**ADC Planning Consultation
Response from the Historic Buildings Adviser**

Application Number	Y/44/15/PL
Address	Yapton Metal Company, Yapton
Description	Sub-division of plot to create 6no. 2-3 bedroom detached and semi-detached dwelling houses.
Case Officer	Simon Davis
Site Visit

Objection

b			
a			
Amendments	by	Date	
Job Title	118 Burn/ADS/PJ		
Drawing			
Elevations (Proposed)			
Scale: 1:100 @ A2			
Drg.No.	ADS-011P		*
Drawn by:	NJH		
Issued to:	Client/LA		
Status:	Planning		
Date	11.05.15

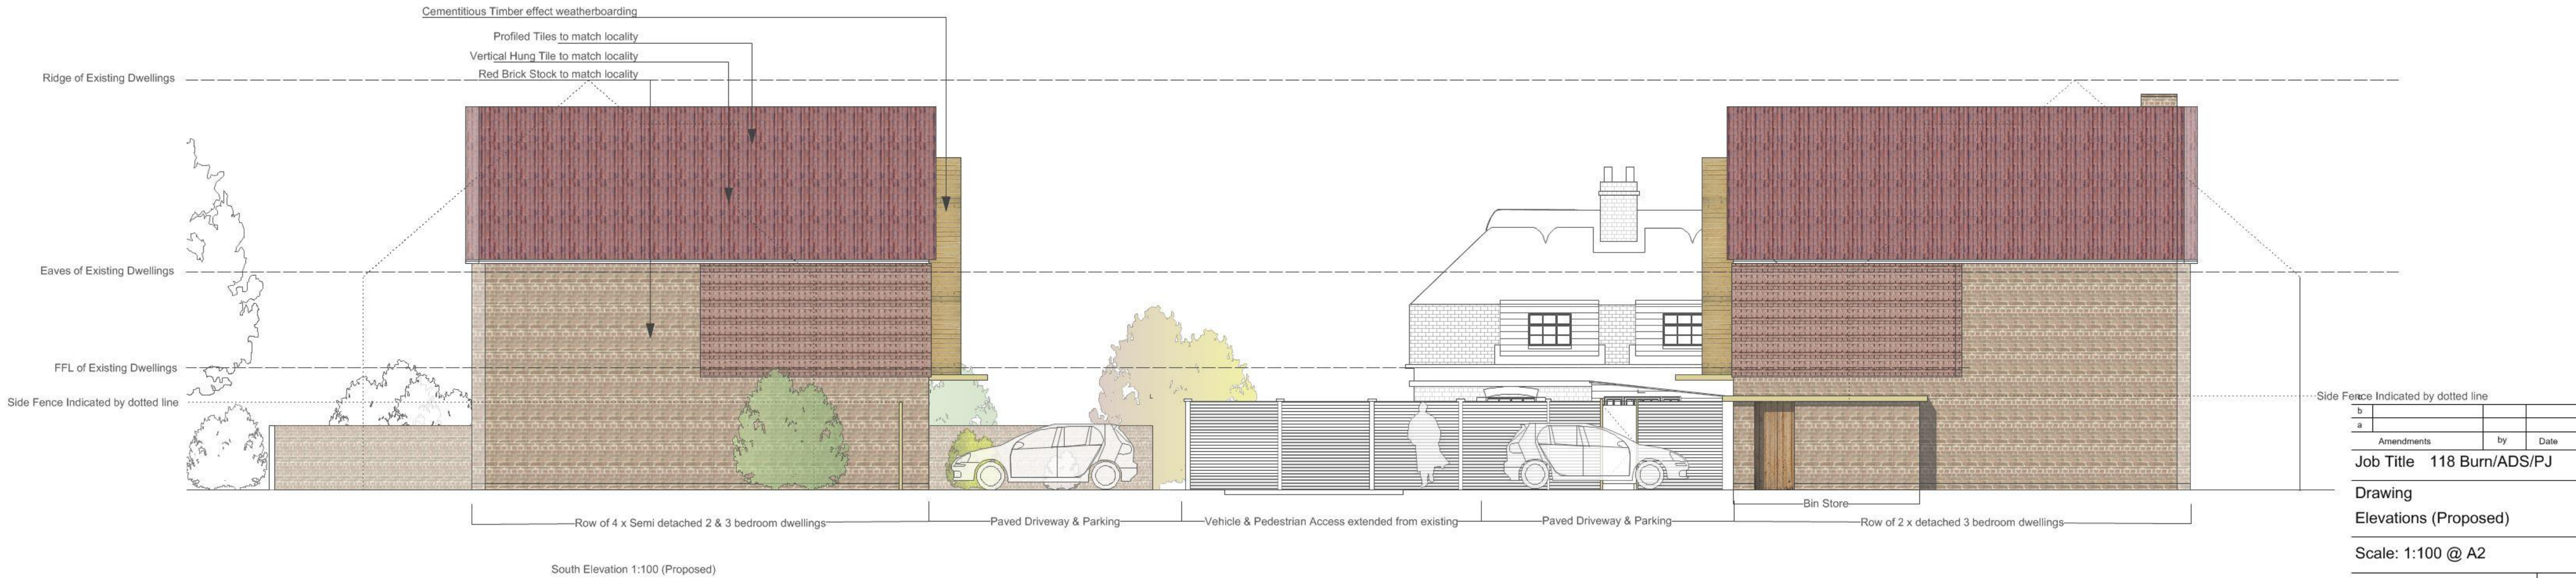
Whilst a setting assessment does not appear to have been carried out in accordance with Good Practice Advice note 3: the setting of heritage assets, the proposed elevations shown in drawings ADS 0101P and ADS-011P would clearly seem to indicate that a level of harm is very likely to be caused to the listed building.
